OUT19/15854

**Maxwell Underground Coal Mine Project (SSD-9526) (Muswellbrook Shire)
Response to Submissions (RTS)**

Mitchell Isaacs
Director Office of the Deputy Secretary and Strategic Relations
Water Group
5 February 2020

**Swamp Oak Forest
 Identified in the Vicinity of the Project**

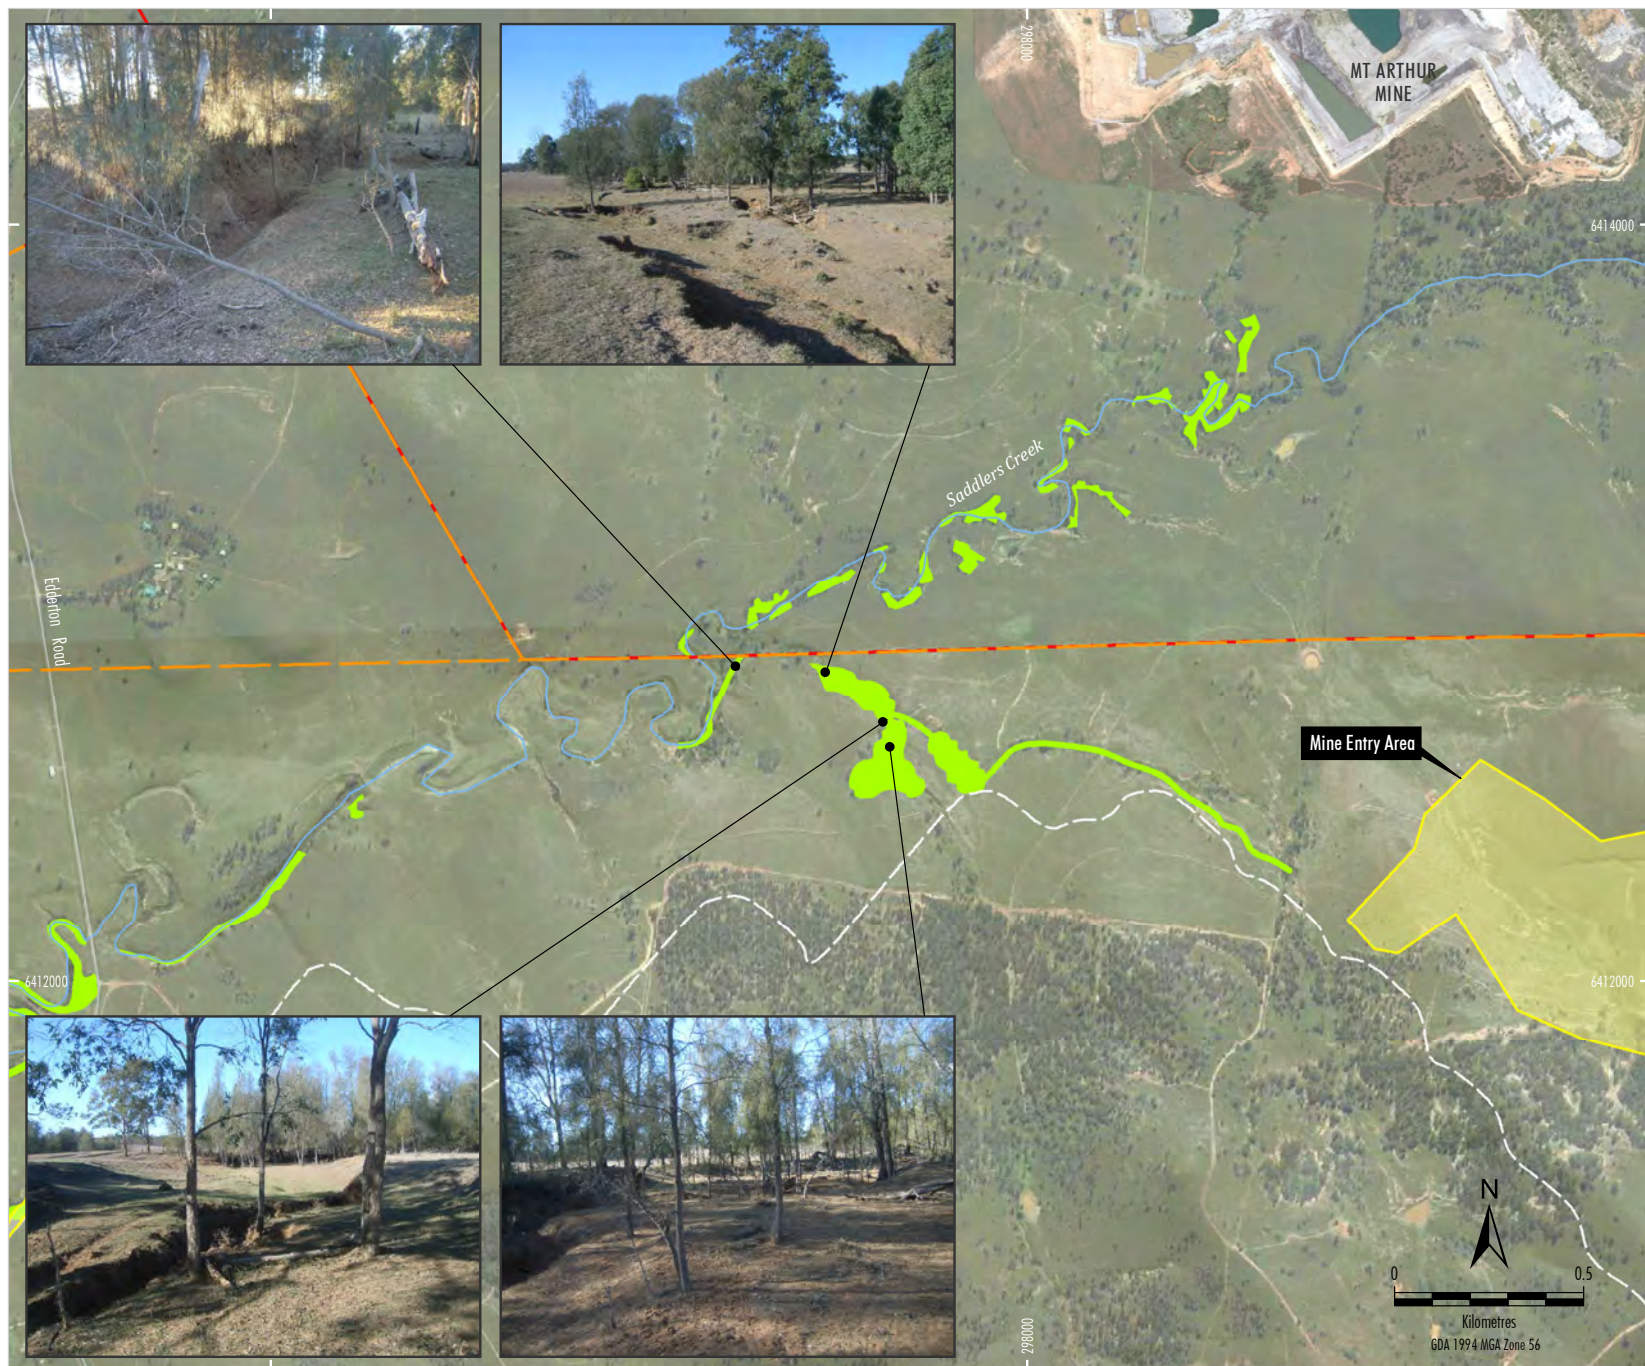
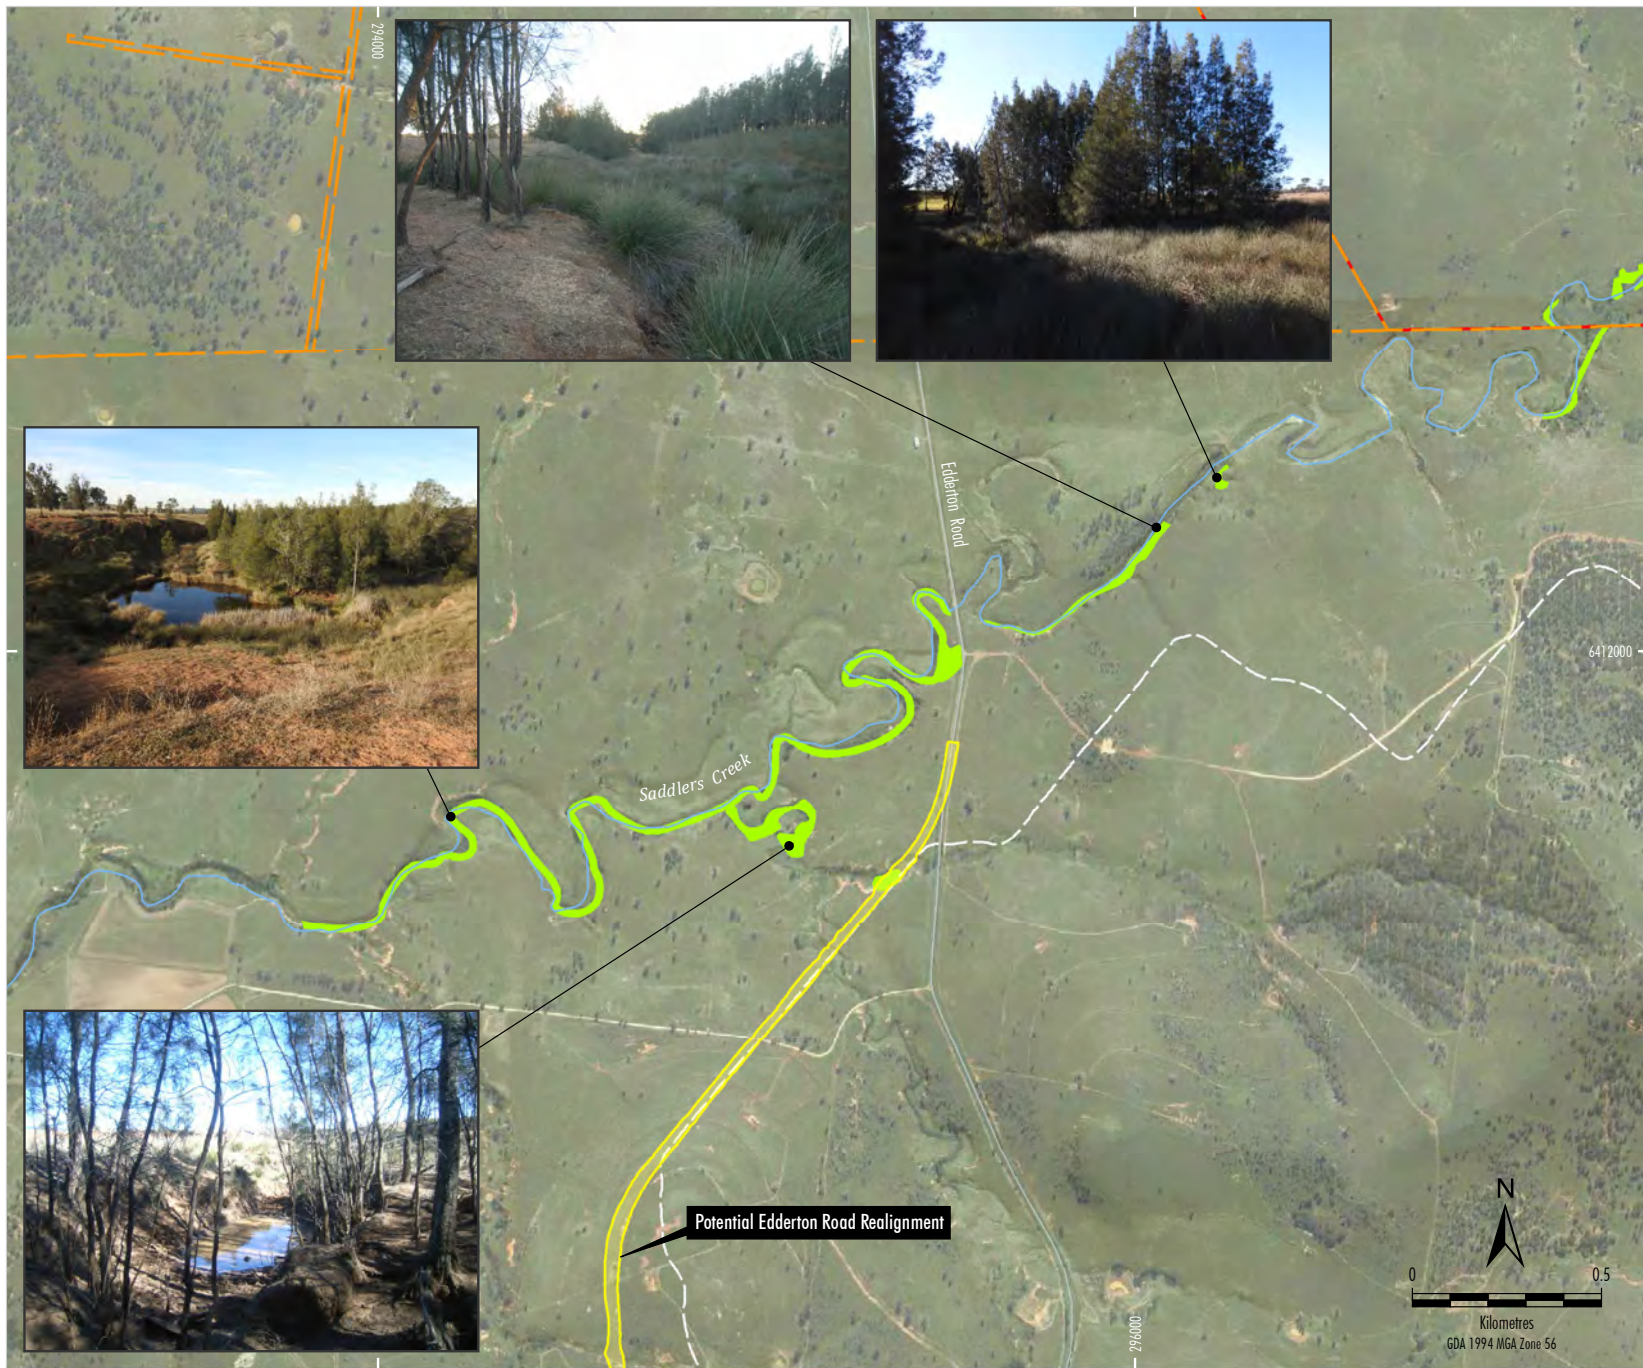
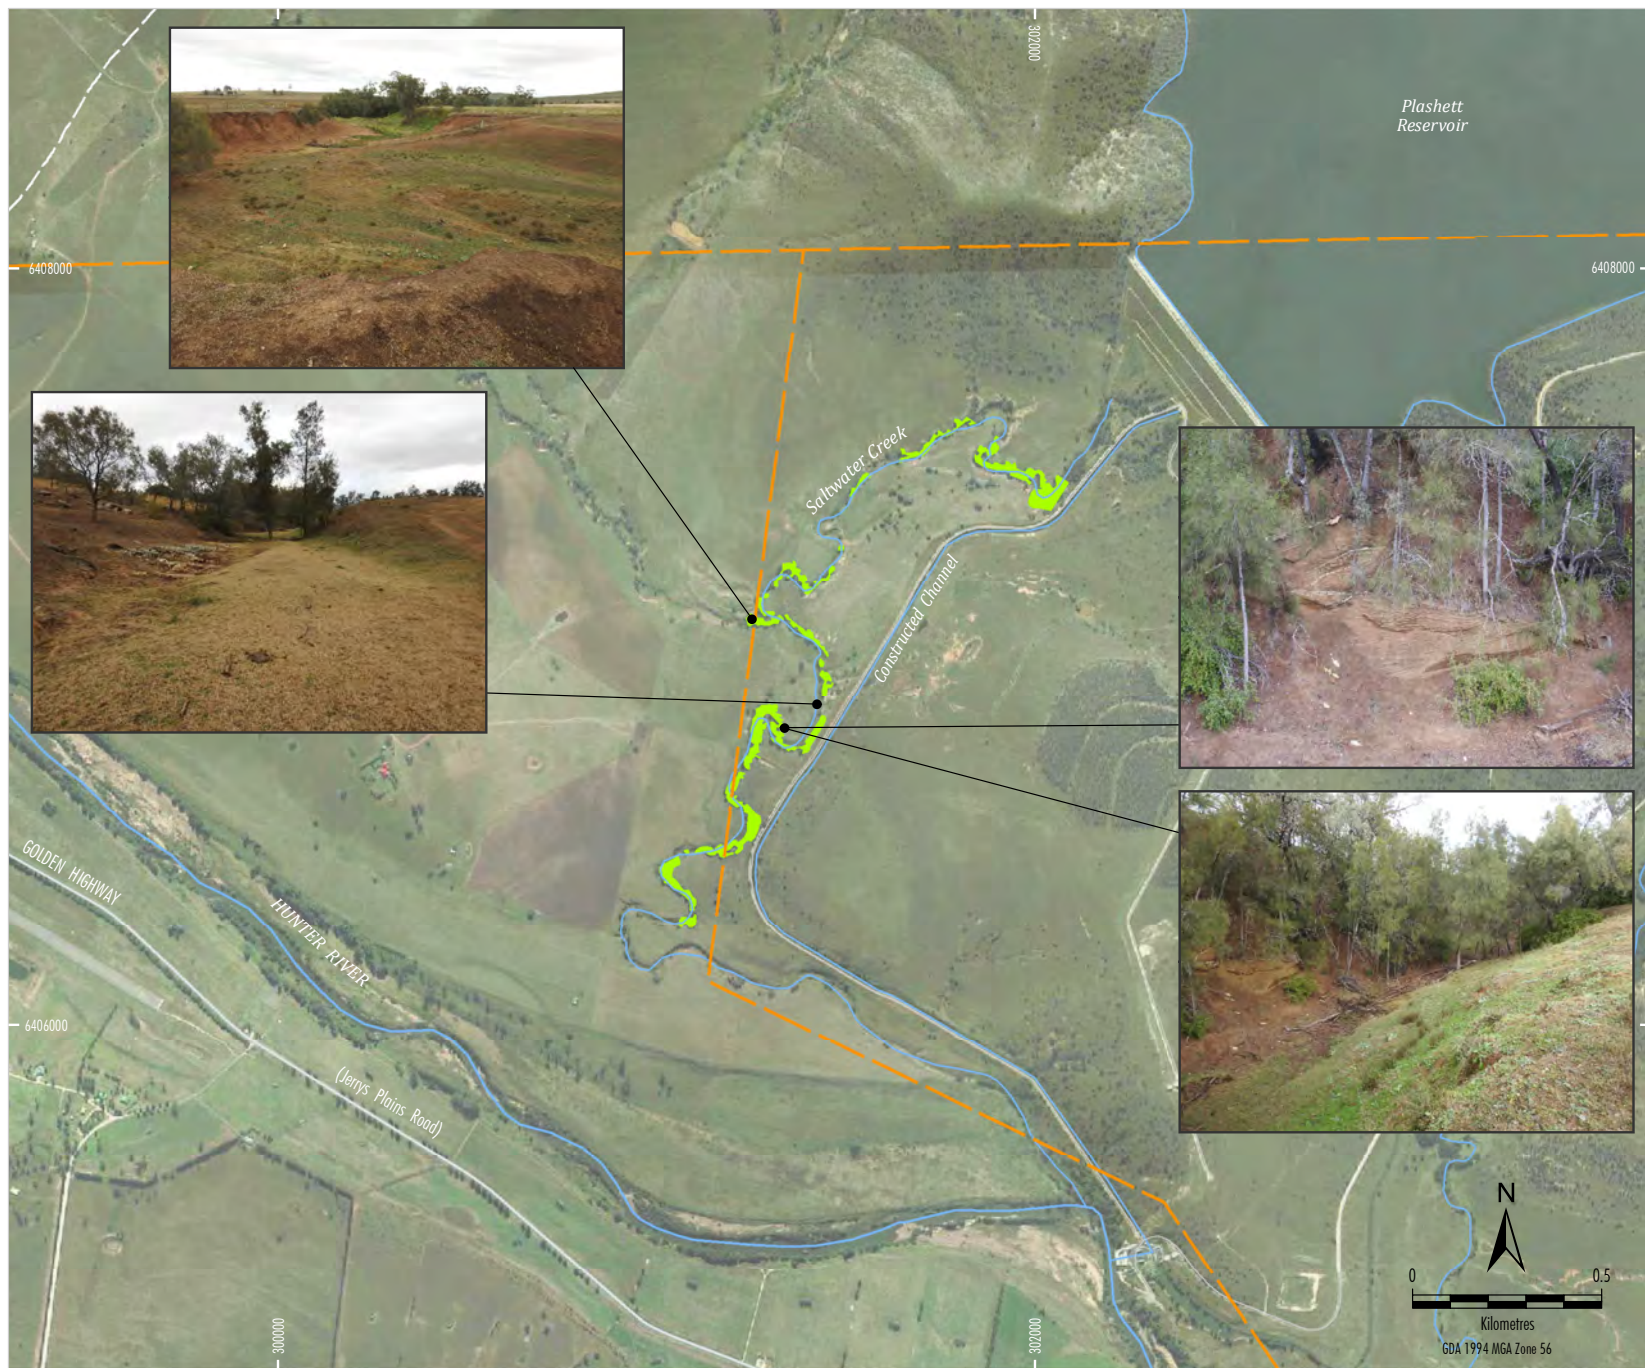
- The proponent should monitor the condition of the potential GDE (Swamp Oak) identified along Saddlers Creek as part of the on-going environmental monitoring requirements of the Water Management Plan.

Chart 1
Monitored Void Water Levels

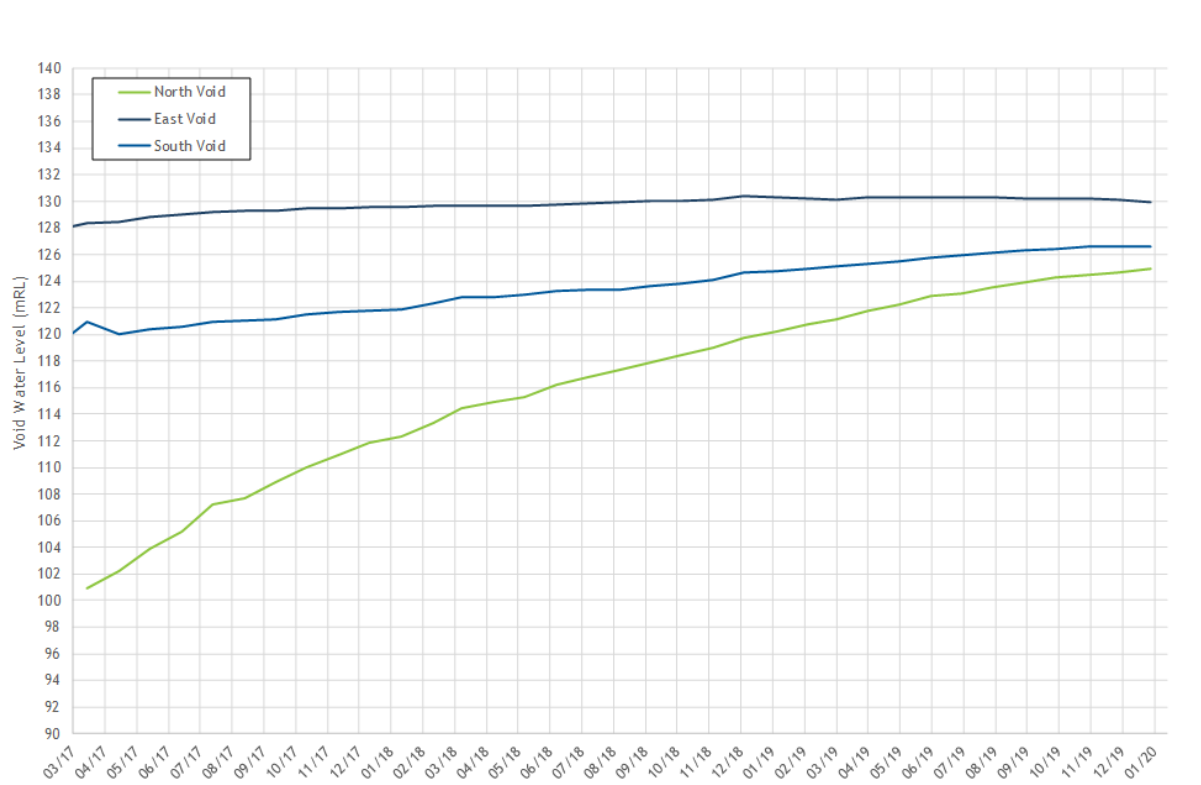
We note that the RTS estimates additional water inflow to the Drayton pit voids to be approximately 2,200 ML/year (6.1 ML/day) and advises that the major source of this additional inflow is seepage from the in-pit spoil with a small contribution from 'external groundwater inflows'. The volume of 'external groundwater inflows' is predicted to be 3 ML/year on average and less than 11 ML/year maximum.

The proponent considers that water sourced from the in-pit spoil is not groundwater take, instead advising that there are only 'external groundwater inflows' of 11 ML/year.

For the purposes of the *Water Management Act 2000*, water stored within mine spoil is groundwater and water that flows to the pit void is licensable take. Consistent with the NSW Aquifer Interference Policy (2012), the diversion of groundwater flow towards the pit voids including that from the pit spoil area is water take. The groundwater licences issued to the former Drayton Mine remain fully committed to account for this take. In effect WAL 41559 or WAL 41491 are insufficient to offset existing Drayton Mine groundwater impacts. Therefore, any entitlement issued to the former Drayton Mine under WAL 41559 or WAL 41491 is not available to offset take associated with the proposed Maxwell Underground Mine Project.

The proponent will need to obtain the full entitlement associated with the Maxwell underground mine and does not hold sufficient entitlement for the first four years of operation. Additional entitlement will also be required to account for the shortfall between the modelled 6.1 ML/day (2,200 ML/year) inflow to the Drayton Pit voids against the entitlement held under WAL 41491 and 41559.

- The proponent should revise their water licensing strategy to account for the combined water take of the proposed underground workings and the take of the legacy mine voids.
